**From:** [REDACTED]  
**Sent:** 05 June 2025 21:30  
**To:** Ben Taylor  
**Cc:** Planning  
**Subject:** App Ref 3/2025/0316 27-29 Bawdlands Clitheroe

I note that an "additional" Planning Statement has been submitted in connection with the above and wish to comment as follows:

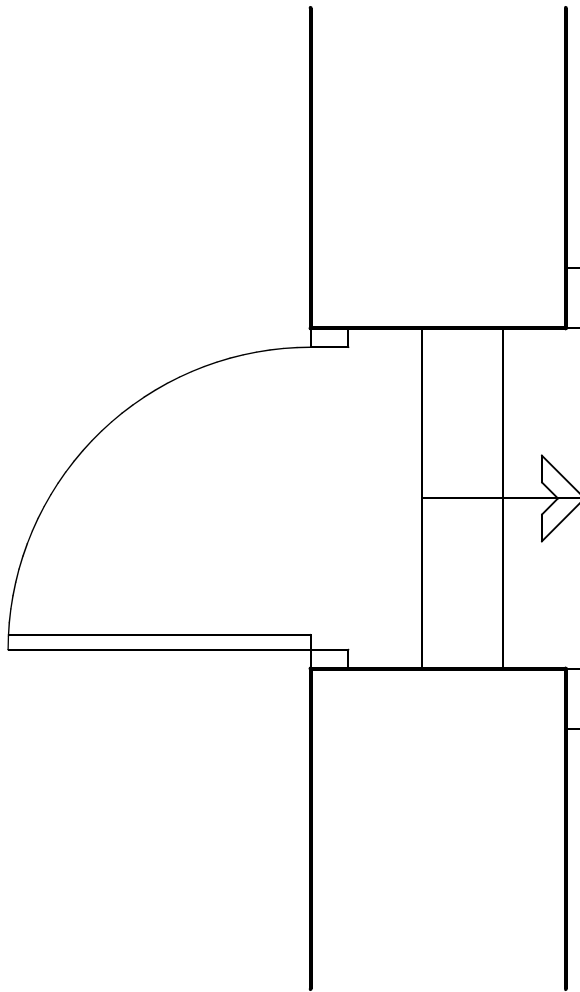
There is no evidence whatsoever that the reduction in occupancy, requiring cycle storage from 8 to 6 bicycles would now render this "small area" adequate when considering the physical manoeuvring of 6 bicycles into and out of this area, especially given the area is shared with bin storage and laundry facilities and is accessed via three steps.

*However, at the time of my site visit, this area was occupied by washing machines and while an external door had been created to Corporation Street, this doorway included three steps down to the pavement. The proposed plans suggest a ramped access, but no section drawing has been provided for this area, showing how the difference in levels would be accommodated, what the resulting gradient would be, and whether the internally opening door could be accommodated with a ramp. As such, I am not satisfied from the information before me, that this internal refuse storage area would be useable by future occupiers, particularly when having to move heavy refuse bins outside for collection. As no alternative refuse storage has been indicated, the proposal has not demonstrated suitable servicing arrangements for future occupiers in this respect".*

The notation that a portable ramp will be provided is far too simplistic, it is not a feasible solution. I refer you to Para 4 of my original objection dated 20th May 2025.
